Application: SSI 7485

I write regarding the proposed modification to M4-M5 Link, Mod 2 The Crescent overpass and changes to pedestrian infrastructure in North Annandale, Rozelle and Rozelle Bay Foreshore area.

Figure 4-2 Pedestrian and cyclist bridge infrastructure options

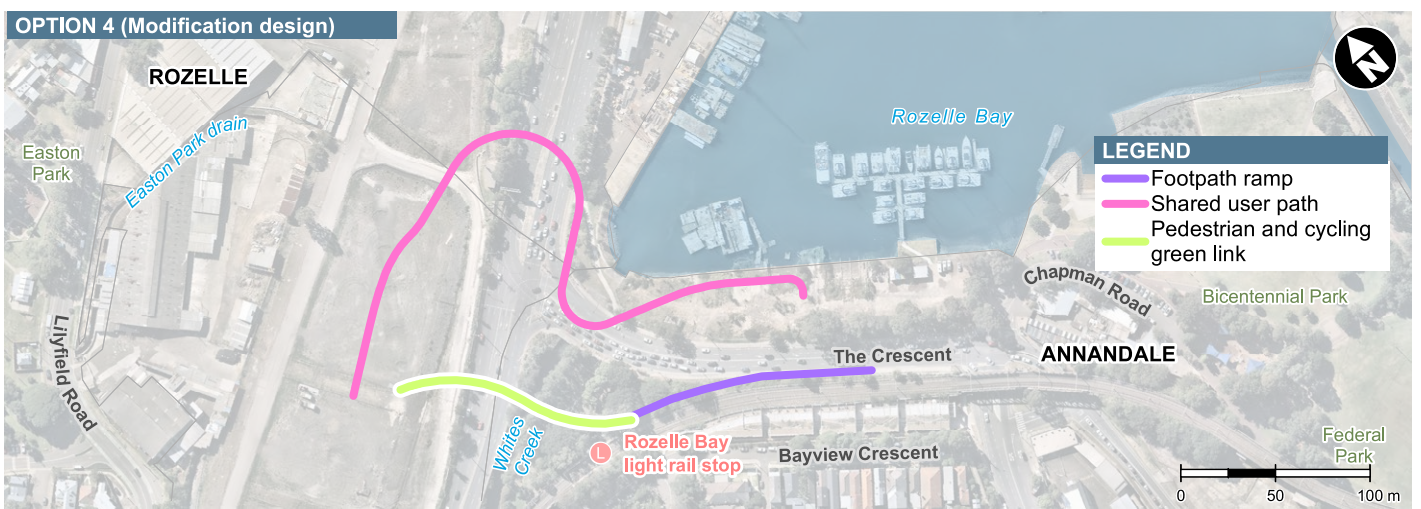
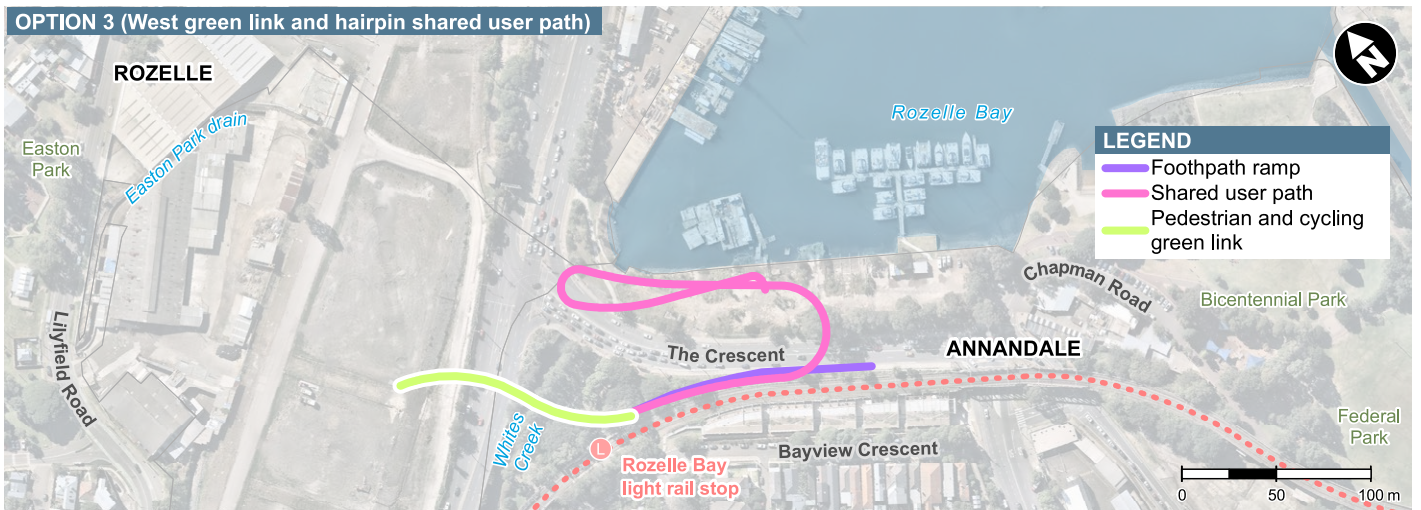
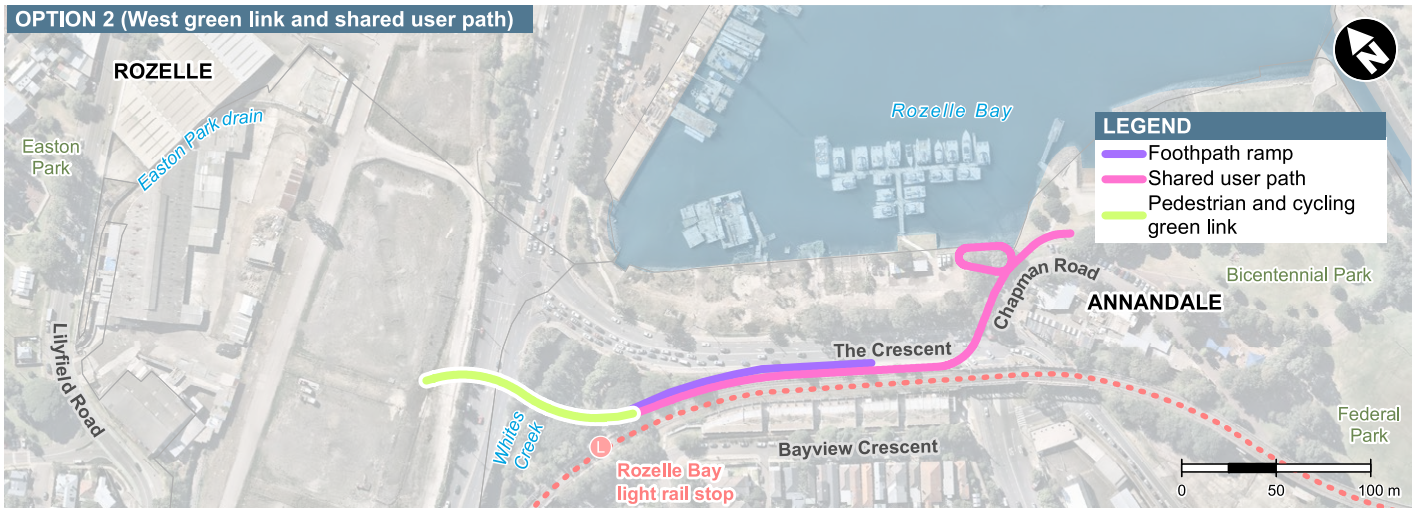
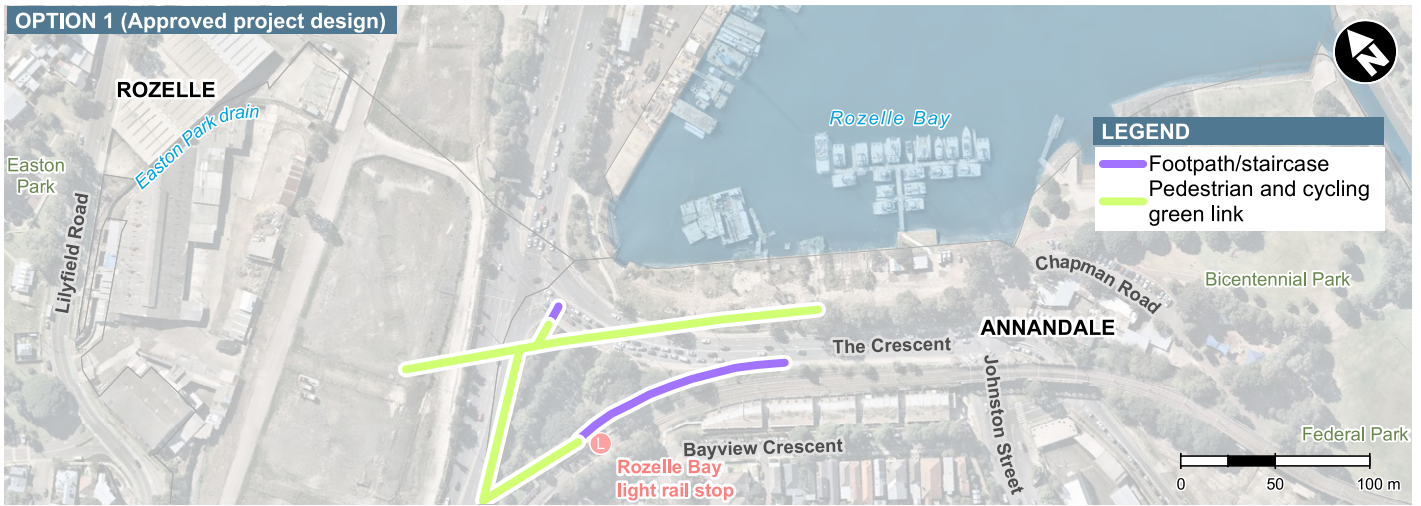
I request RMS work with the community to explore alternate design options to the proposed new car overpass design and the changed pedestrian and cyclist links. I am seeking the reinstatement of the safe, direct access from the approved EIS GreenLink to create a continuous green open space connection from the Rozelle Rail yards and Annandale to the foreshore. The GreenLink was more than just a walk way - it put people central to the design, maximising safety, and providing much needed accessible open space for the community now and into the future Bays Precinct design.

- The significantly reduced safety and increased risk for pedestrians and cyclists with removed access over The Crescent to Bicentennial Park and the increased traffic along Johnson Street.
- Being required to cross five sets of pedestrian lights at The Crescent as my option to reach the foreshore from Annandale or from Rozelle Bay light rail stop.
- Removal of direct active links to the foreshore, cutting the community off from the area and the proposed revitalisation of the entire Bays Precinct, including linking the Light Rail and Bus stops to a Ferry wharf and Metro station.
- Urban and landscape design that is being built before a finalised Masterplan for the area.
- Traffic changes that limit movements around the suburb and create further congestion in the local streets of Annandale, Forest Lodge, Glebe, Lilyfield and Rozelle with no planning to deal with these.

- Reinstate the GreenLink connecting communities and green open space from Rozelle to Bicentennial Park
- Relocate and design pedestrian and cyclist connections that are continuous, safe and direct.
- Design the modification infrastructure and active links in response to the character of the suburbs, the location of the foreshore and it's potential future development.
- Provide pedestrian and cyclist paths that maximise people safety and do not force them onto busier streets, unsafe concrete plazas and caged walkways.
- Integrate active and direct connections to all active transport – including the future Metro West and Foreshore Ferry Wharf

Figure 4-3 The Crescent, Johnston Street, Chapman Road intersection options

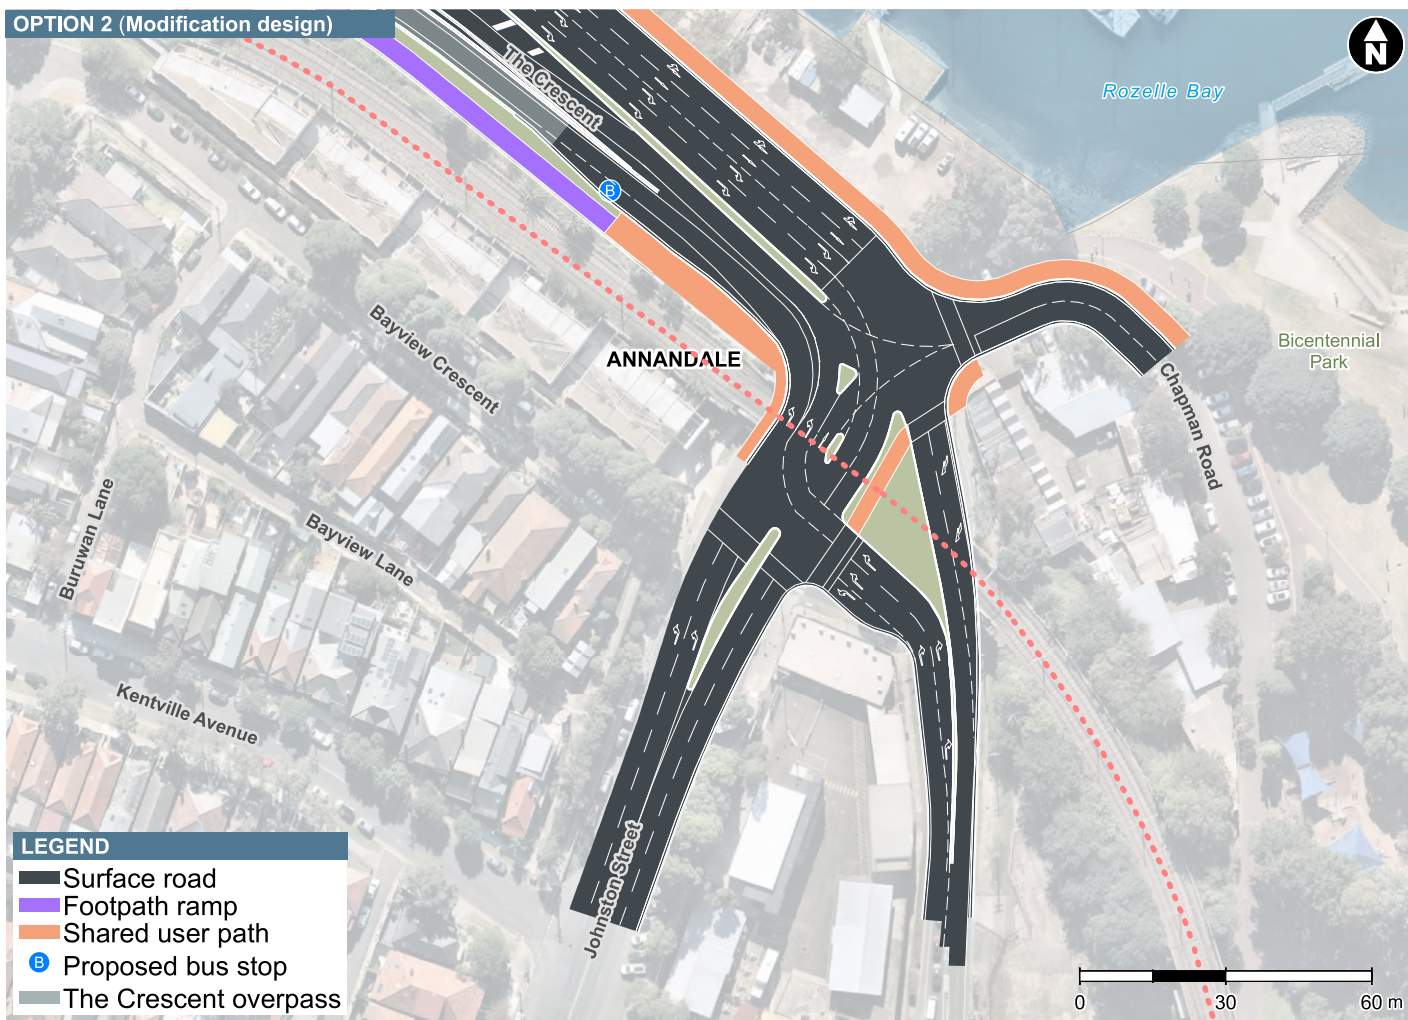
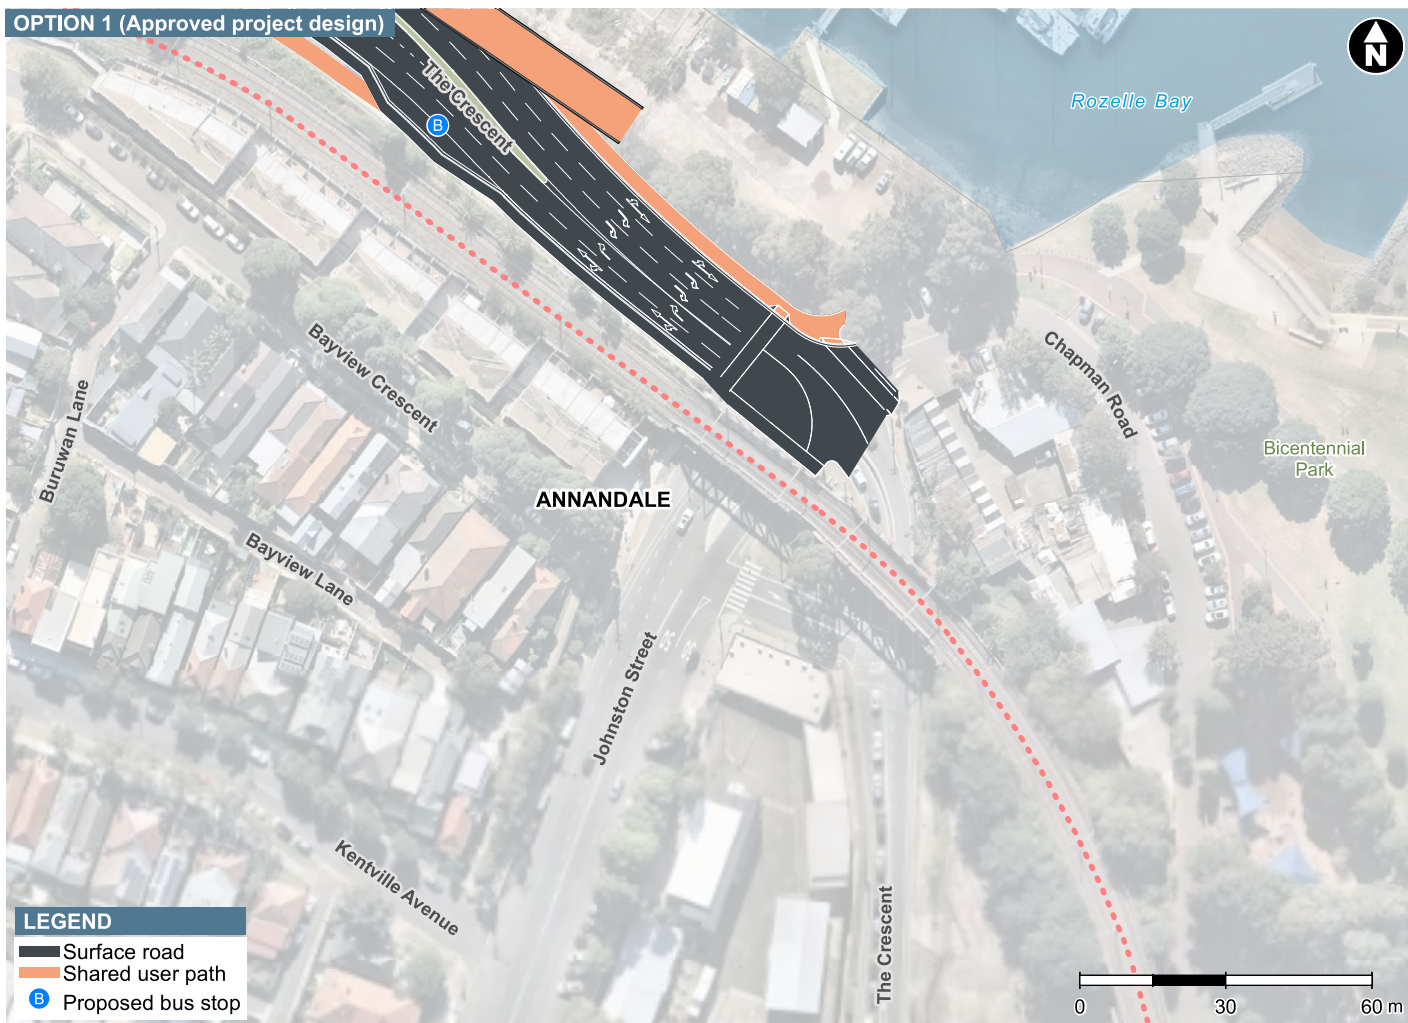
Annandale North Public School and Annandale Primary regularly access ~~the~~ Bicentennial Park via the Crescent. They will now have to cross 4-5 sets of traffic light to do so. Cars before kids???
